**OXFORDSHIRE COUNTY COUNCIL'S RESPONSE TO CONSULTATION ON THE  
FOLLOWING DEVELOPMENT PROPOSAL**

**Application no:** 14/01682/REM

**Proposal:** Reserved Matters to application 06/00967/OUT – Erection of 226 dwellings, landscaping, roads and associated infrastructure on parcels KMA and KMB

**Location:** Land South West of Bicester Adjoining Oxford Rd & Middleton Stoney Rd, Bicester

DRG TITLE:
 HOUSE TYPE GG2 (1112)
 FLOOR PLANS

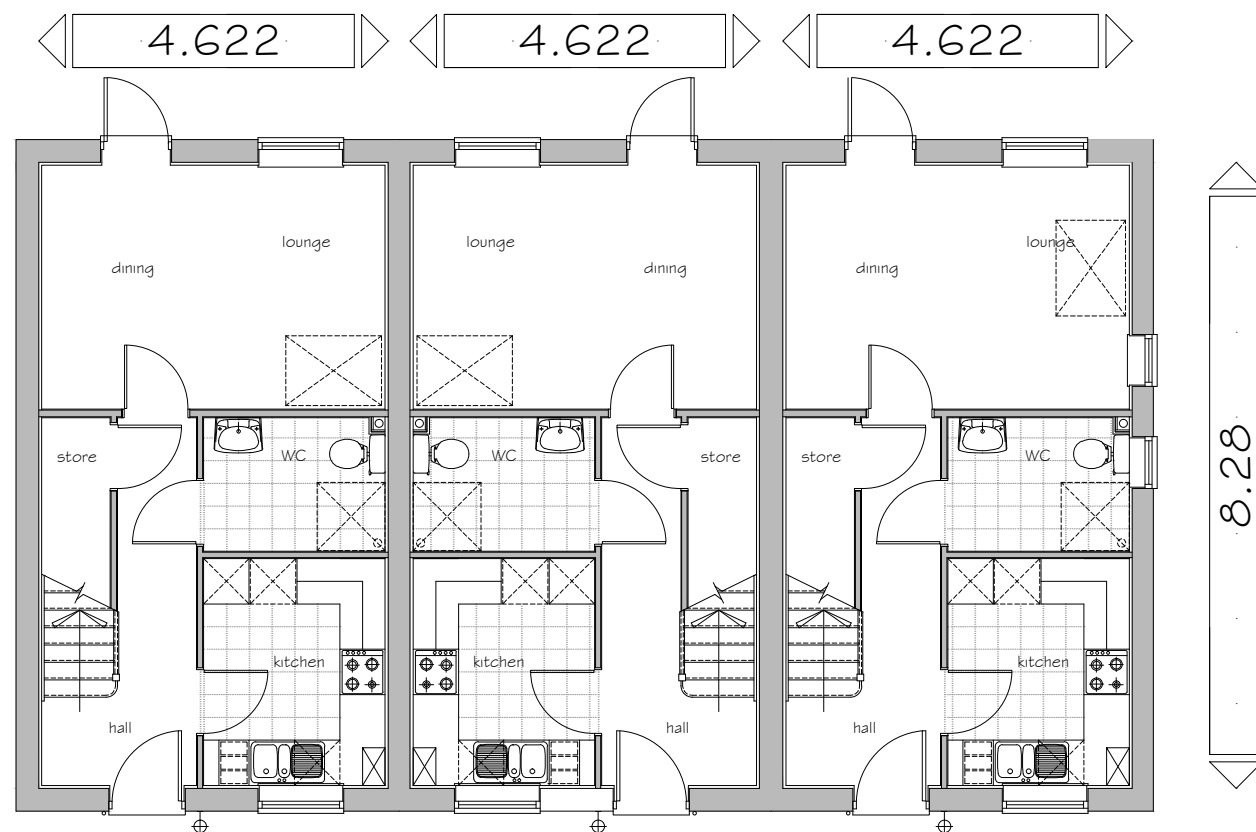
- No bus tracking has been submitted for consideration
- It is unclear in terms of practically of the parking arrangement for plots 119 and 120; vehicle tracking diagrams will need to be submitted for consideration
